June 3, 2016

Re: Betos Boots
5901 Rio Vista Dr., SW
Traffic Circulation Layout
Engineer's/Architect's Stamp **5-17-16** (L11-D068)

Based upon the information provided in your submittal received 5-26-16, the above referenced plan cannot be approved for Building Permit until the following comments are addressed:

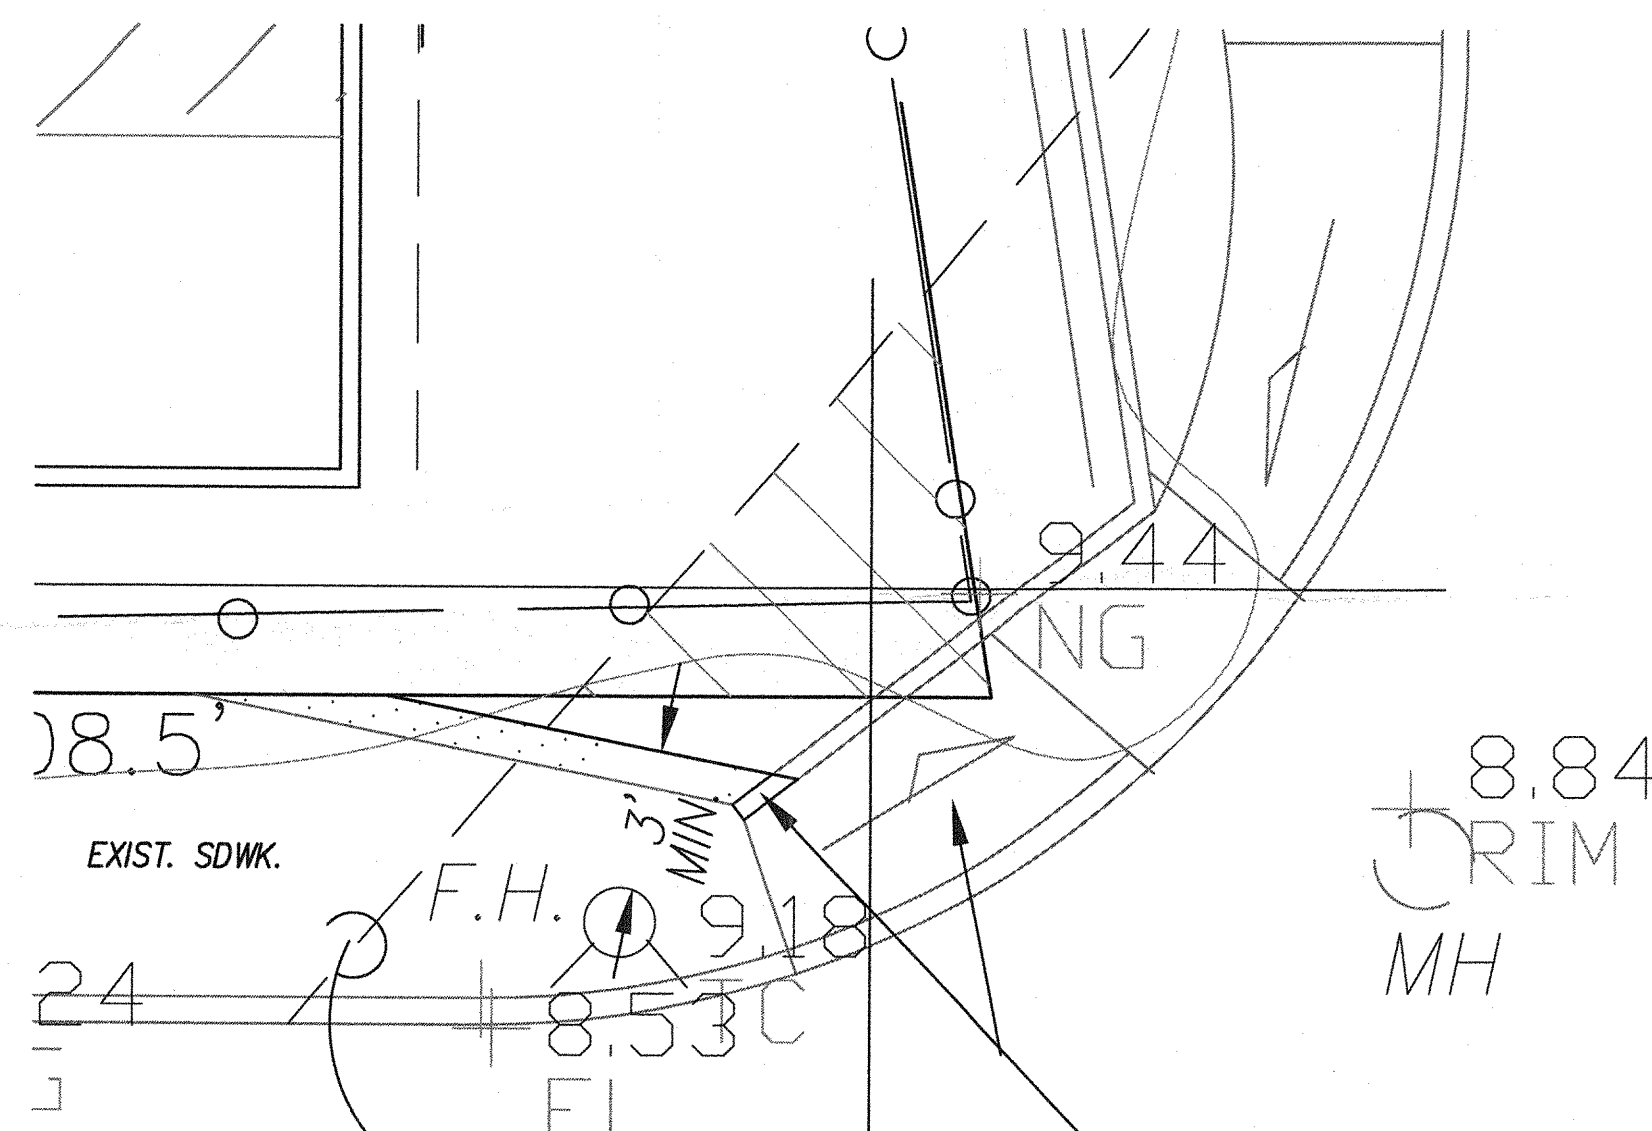
1. Identify all existing access easements and rights of way width dimensions.
2. Identify the right of way width, medians, curb cuts, and street widths on Rio Vista Dr.

3. The ADA access aisles shall have the words **"NO PARKING"** in capital letters, each of which shall be at least one foot high and at least two inches wide, placed at the rear of the parking space so as to be close to where an adjacent vehicle's rear tire would be placed. (66-1-4.1.B NMSA 1978)

4. Per DPM, a 6 ft. wide ADA accessible pedestrian pathway is required from the HC parking stall access aisles to the building entrances. It is preferable that the ADA pathway does not cross the drive pad. Please review if HC parking can be placed at the north west parking spaces.

5. Provide a min 6" or max 8" high concrete barrier curb or other acceptable barrier between landscaping and parking areas and/or drive aisles. Please call out detail and location of barrier curb.

6. Service vehicle and/or refuse vehicle maneuvering must be contained on-site; provide a copy of refuse approval.
7. Please provide a sight distance exhibit (see the *Development Process Manual, Chapter 23, Section 3*). Please show this detail for the entrance/exit off of Rio Vista Dr. and the public alley.

8. All broken or cracked sidewalk must be replaced with sidewalk and curb & gutter. A build note must be provided referring to the appropriate City Standard drawing.
